Application by DS Smith Paper Limited for The Kemsley Mill K4 Combined Heat and Power Generating Station

The Examining Authority's Written Questions and Requests for Information (ExQ1)

Issued on 24 July 2018

Document number  
4.9

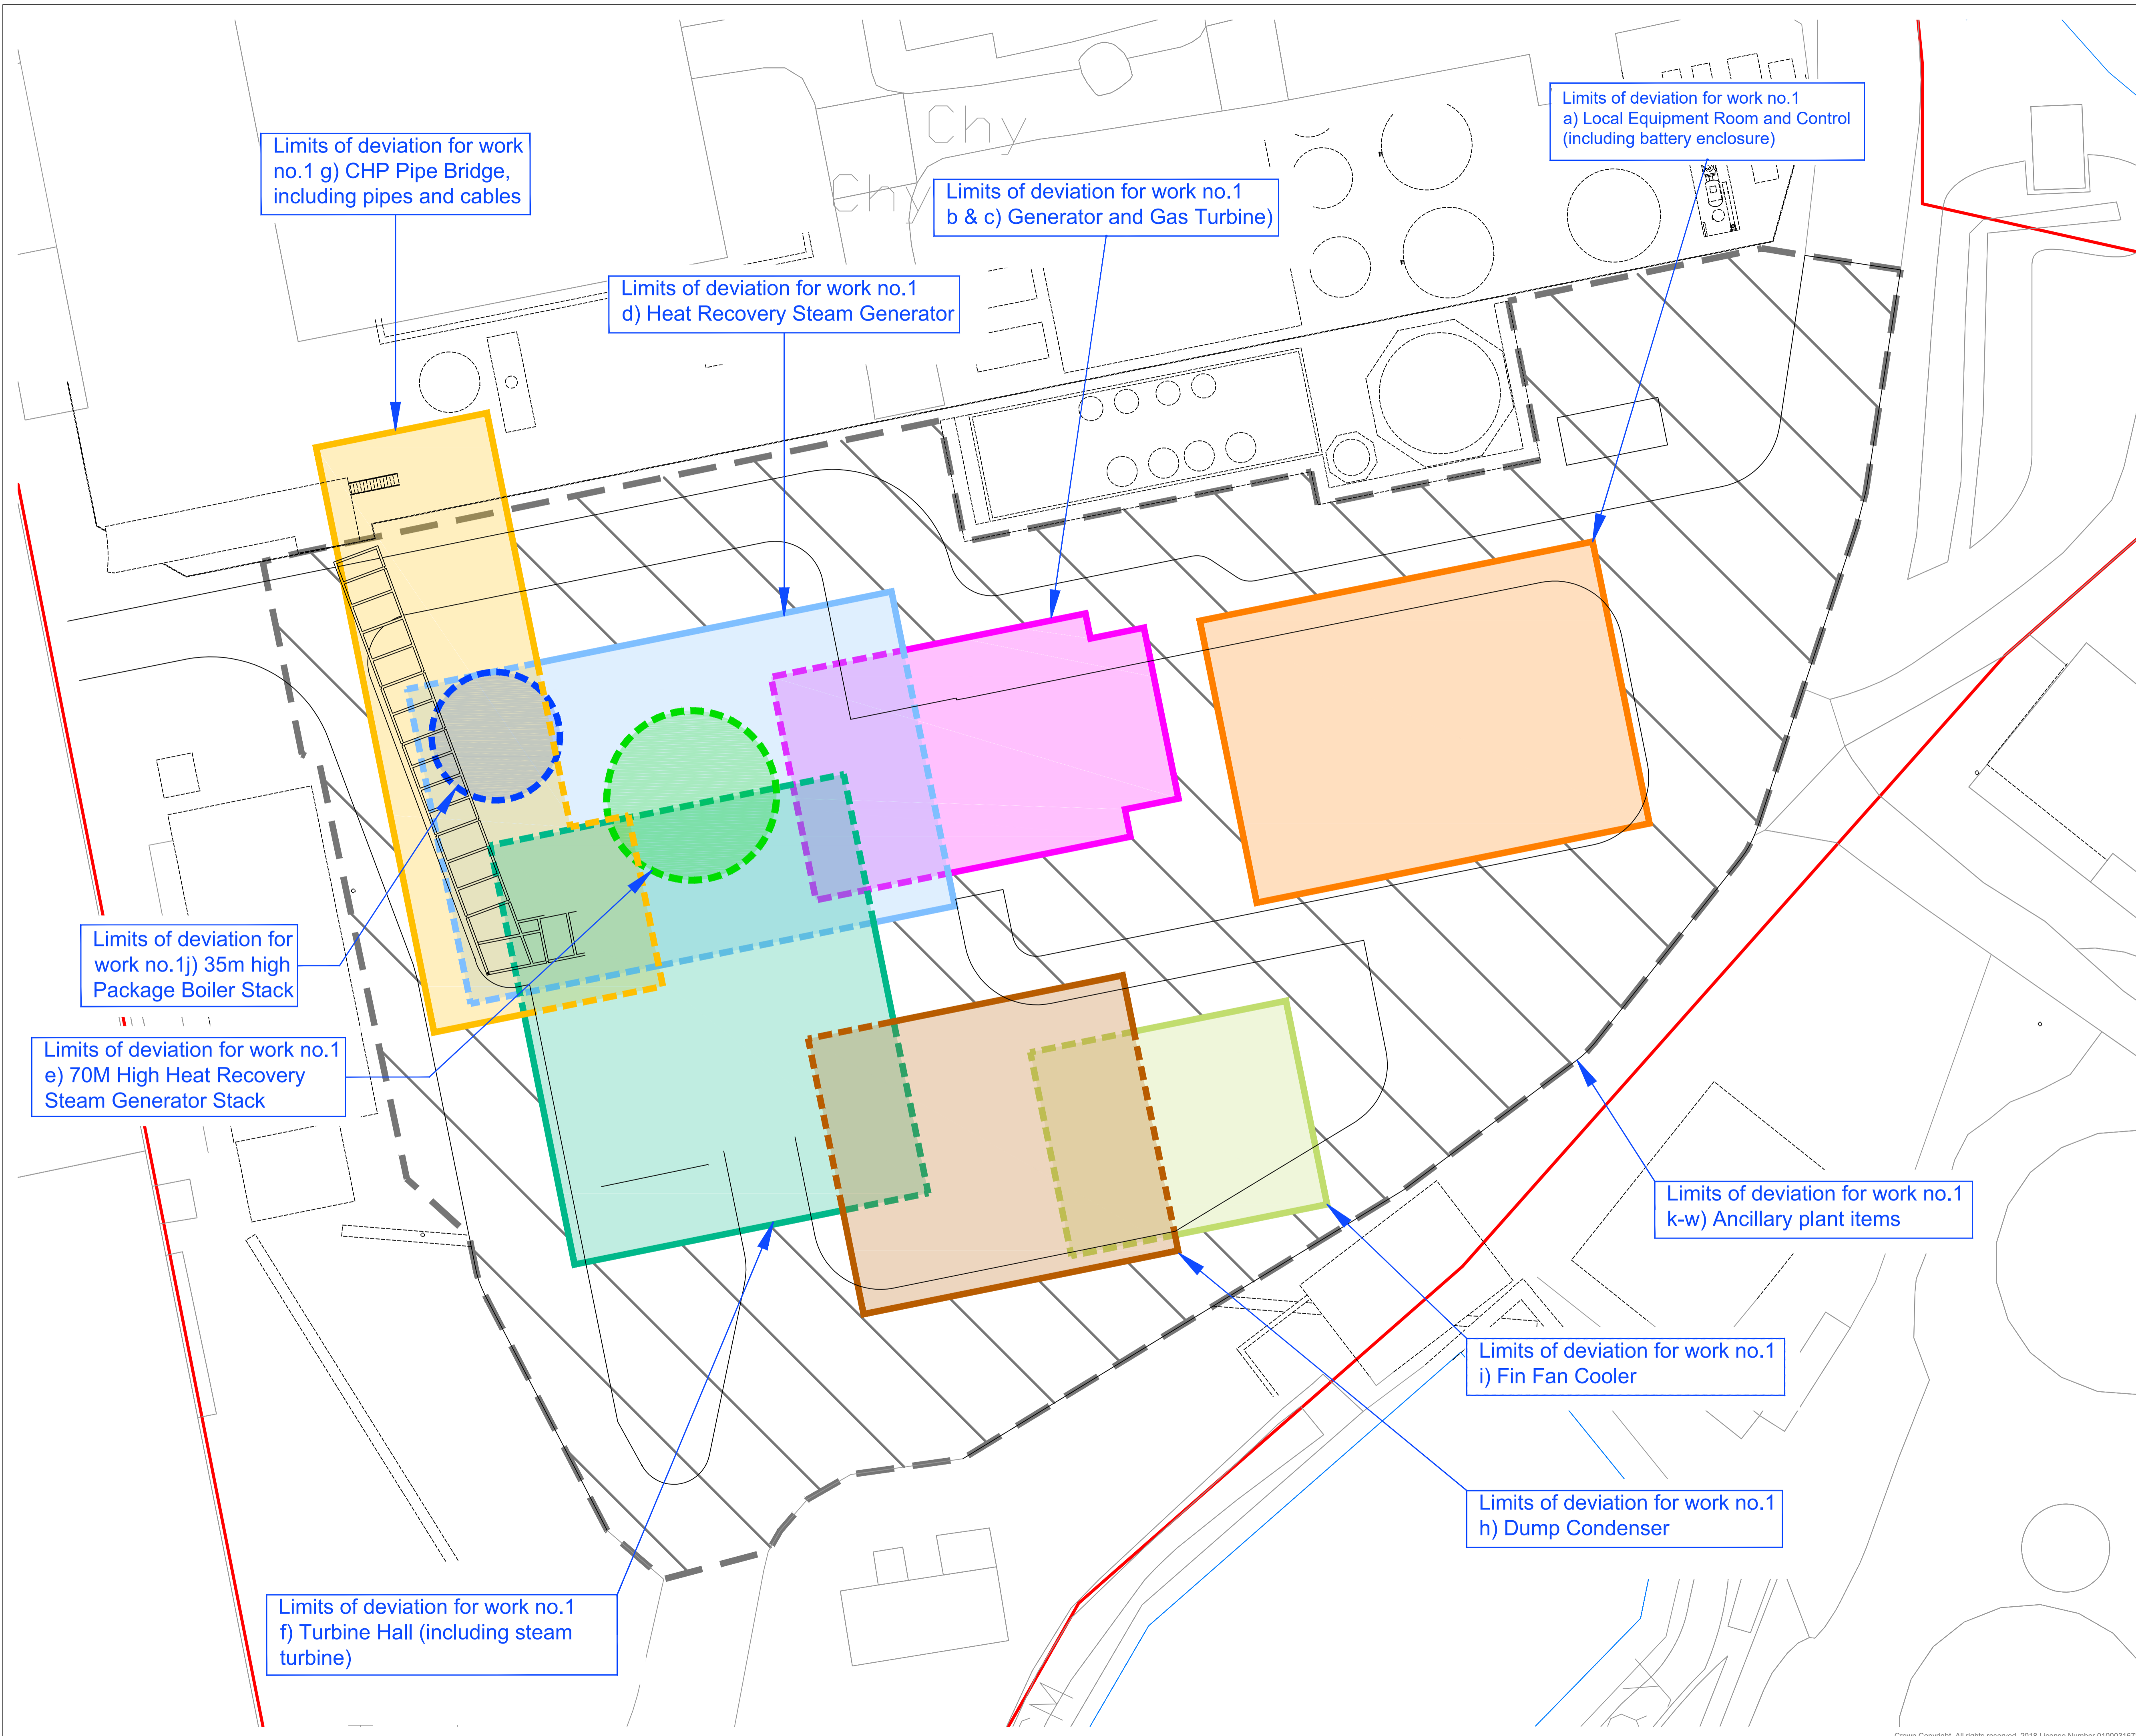
Q1.1.3	Applicant	The Works Plans [AS-004 and AS-008] for the alternative boiler options show the limits of deviation. Please could the Applicant demonstrate that the ES considered the effect of each alternative within 5m variation in any direction as described in paragraph 10.4 of the Design and Access Statement (DAS) [APP-058] How was the 5m parameter determined?
Q1.1.4	Applicant Environment Agency	The description of construction facilities and equipment set out in paragraph 2.5.6 of the ES [APP-008] differs from item (e) of the further development described in Schedule 1 of the dDCO [APP-005]. Please could the Applicant demonstrate that the ES has taken account of all of the elements described in (e)?
